REMARKS TO THE PUD PUBLIC MEETING 4/21/26 9am
Kittitas PUD #1 Proposed Headquarters Relocation SE-26-00003

George Thomas, adjacent landowner, active farmer, and commenter SE-26-00003

1 OVERALL SITE PLAN
1" = 60'-0"

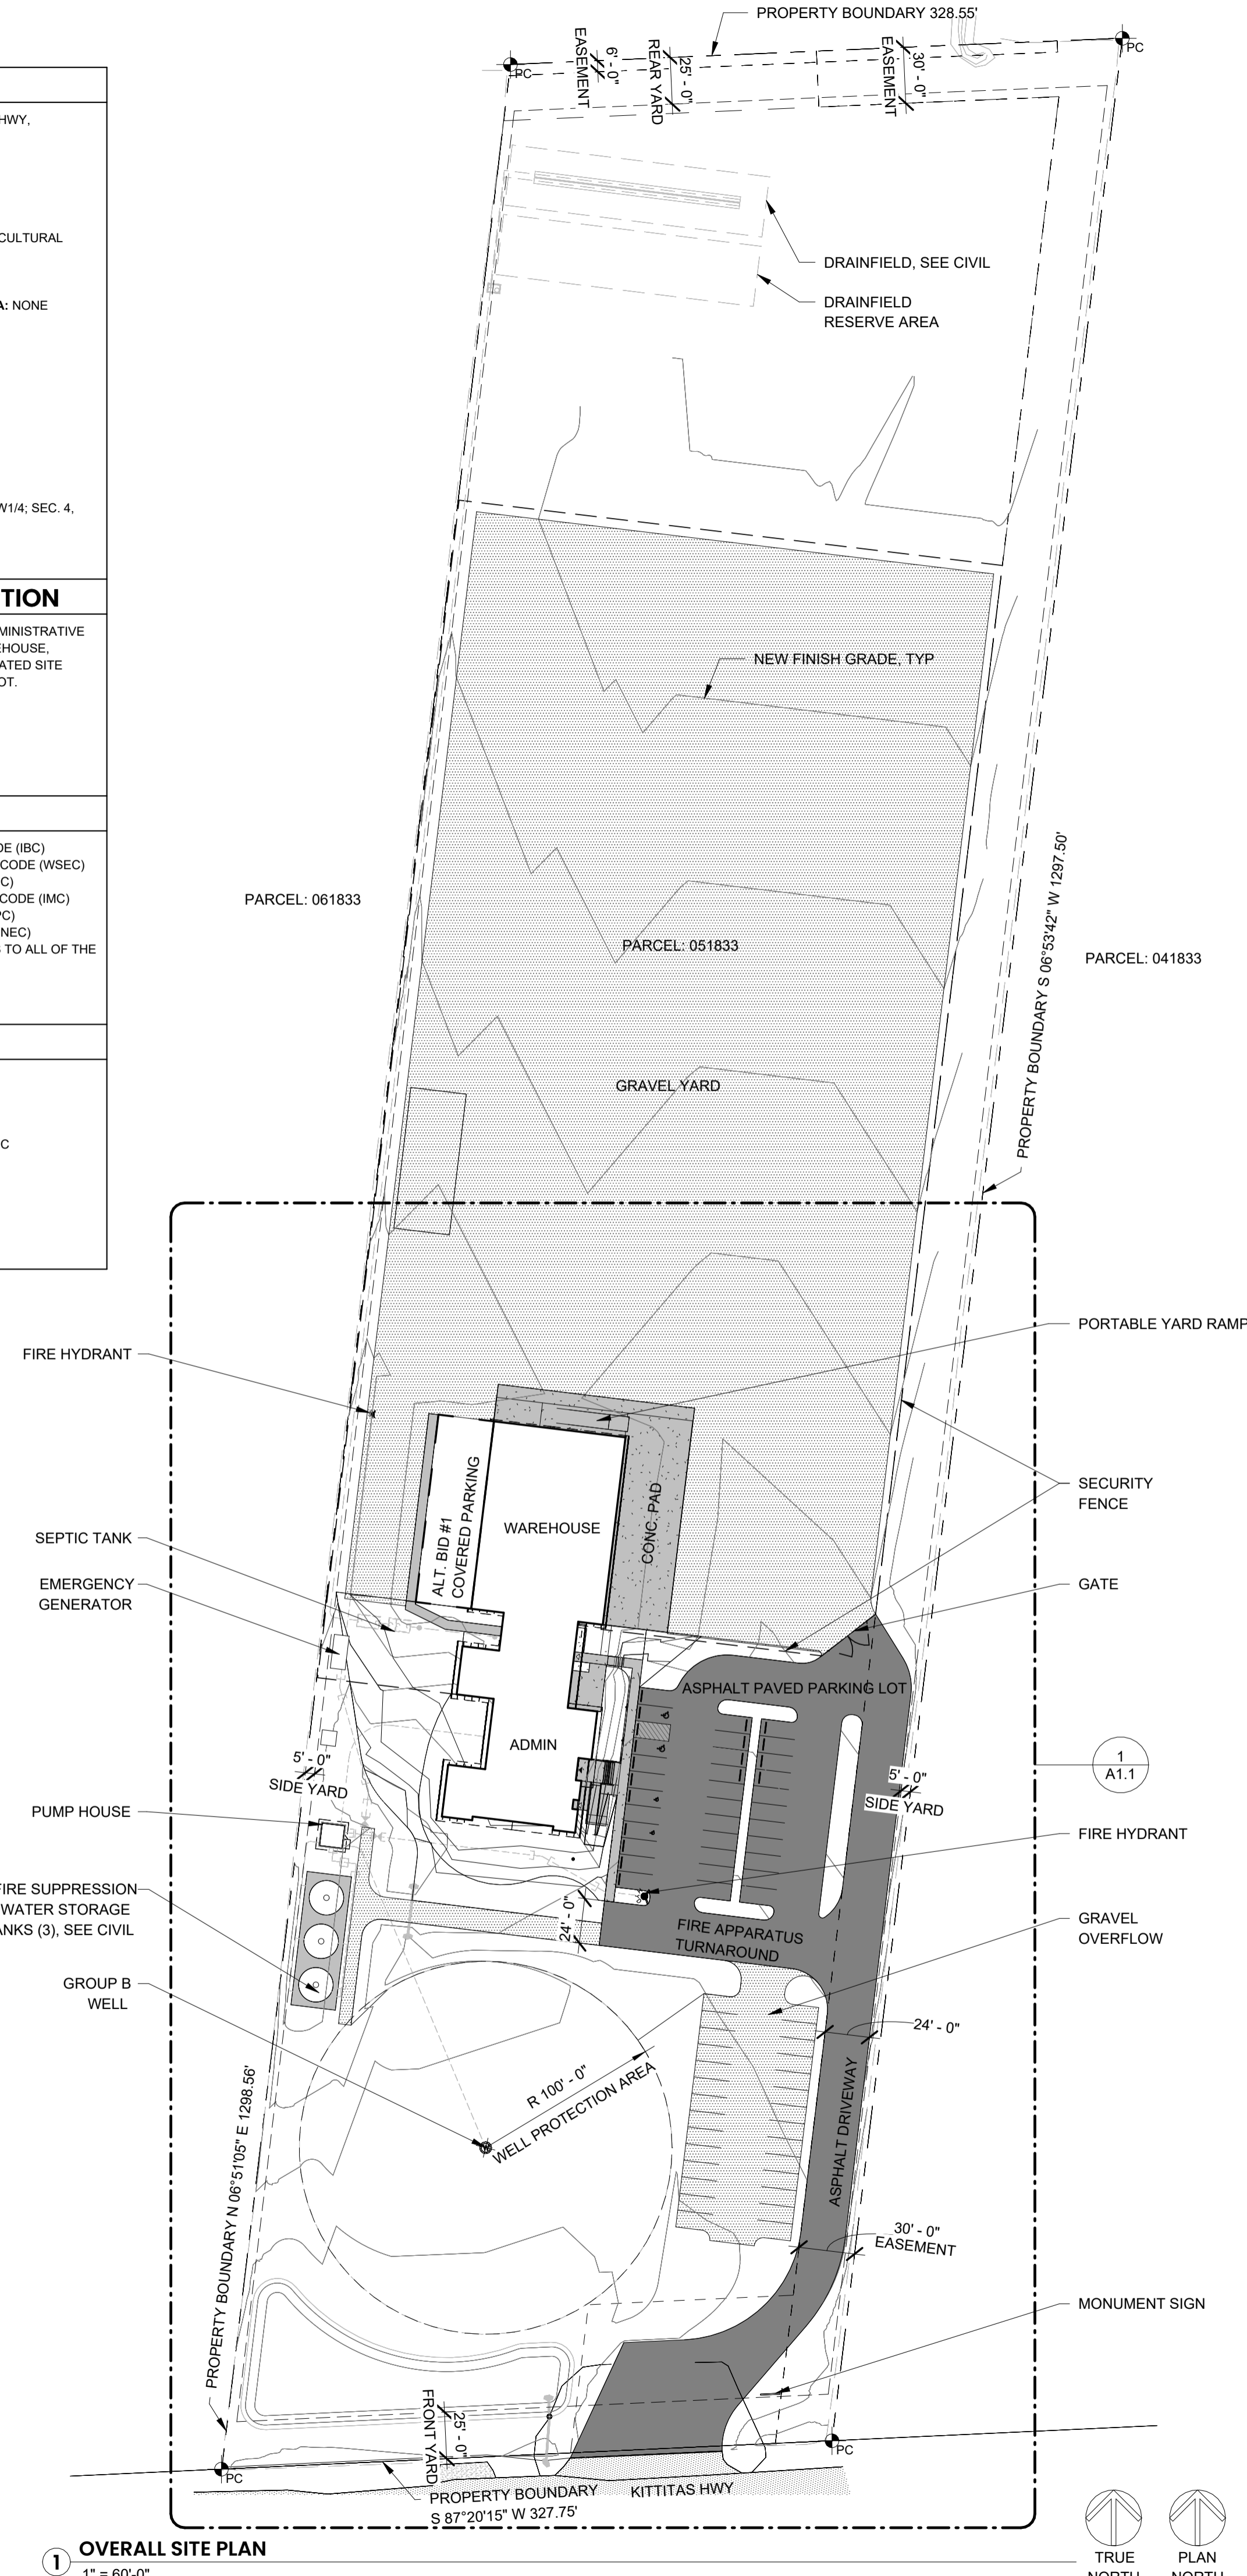
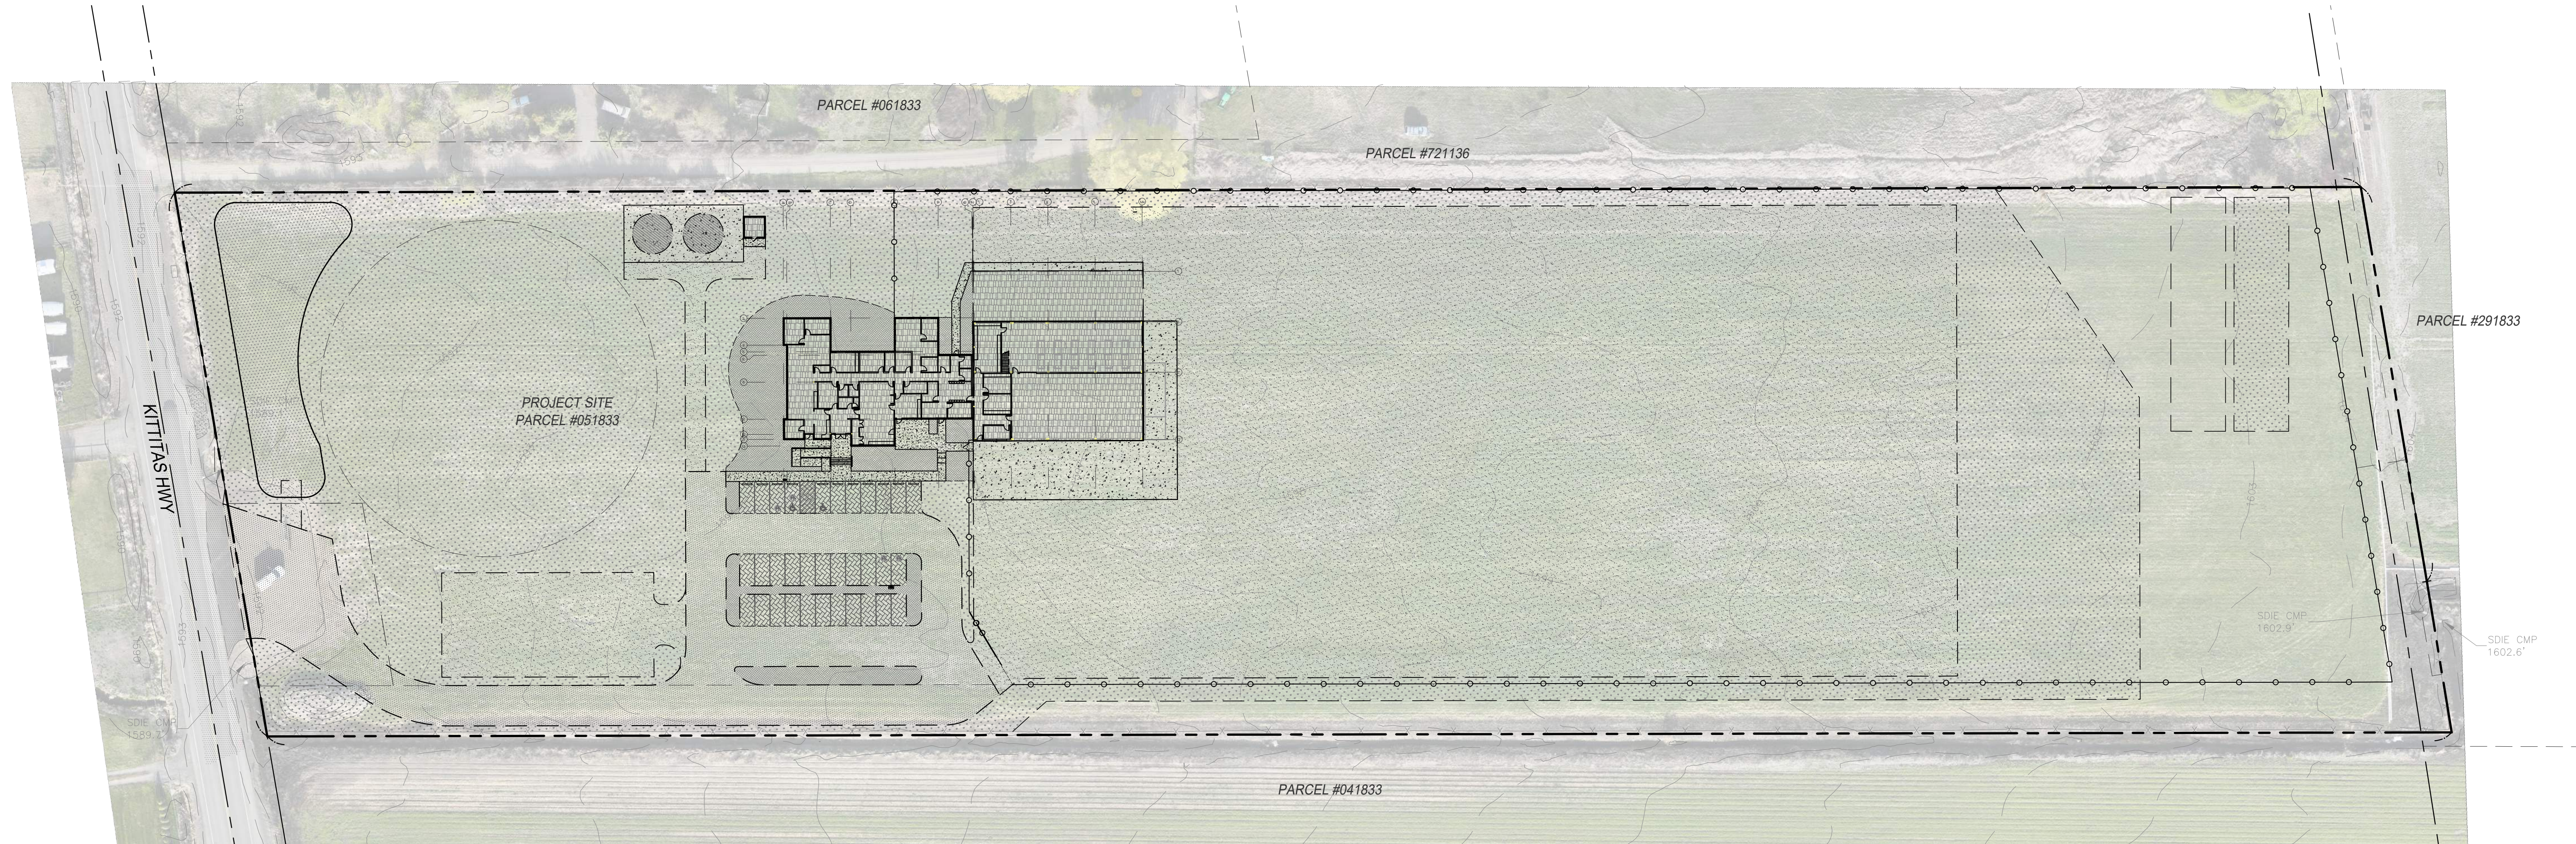
Your own drawings narrow the recorded thirty-foot easement to a twenty-five-foot paved strip. That is a seventeen percent reduction in a recorded width, accomplished without my consent, without a recorded amendment, and without consideration.

Your plan then installs a rigid perimeter fence along the easement corridor, replacing open agricultural access with a hard industrial edge. It introduces a sharp turn at the northeast corner of your parcel a geometry my oversized farm equipment cannot navigate. And in place of the clear passage the instrument guarantees me, it routes my access directly into a drainage ditch. That ditch originates along Ferguson Road, runs north-south, turns east, turns south, and parallels the entire length of your parcel. It overflowed this past winter.

Nothing on this site plan justifies a narrowing, a rigid fence, a sharp turn, or a forced diversion into an overflowing ditch. All four are textbook unreasonable interference. And because the dominant estate holds the controlling property right not the servient estate the decisions about runoff management, access geometry, and any construction activity that touches the easement corridor are mine to approve. Not yours to impose.

And then there is the soil itself. Converting this parcel to the proposed facility requires stripping approximately 14,000 cubic yards of Prime Farmland topsoil roughly 1,868 heavy truck trips to haul it out and importing an equivalent volume of aggregate to replace it. The site plan then commits 5.79 acres, 60 percent of the parcel, to permanent industrial gravel. Total impervious surface reaches 53.5 percent.

Fourth, where those chemicals end up if the checklist is allowed to stand. Your drainfield and reserve area are sited at the north end of this parcel within 100 feet of a small pond on the adjacent property to the west, and directly downstream of approximately 25 million gallons of annual flood irrigation on the parcel immediately upgradient.

Your site plan shows up to 180,000 gallons of fire suppression capacity. At 275 gallons per day, filling those tanks takes 655 days. The water source is not in the record.

Sixth, the lighting. Your letter to the public promised dark-sky alignment motion-activated lights, used only during outage response. Your own SEPA checklist states the storage yard will be lit "when it's dark outside." That is permanent nightly illumination of a nearly six-acre industrial yard, in a landscape that has been rural and dark for a hundred years.
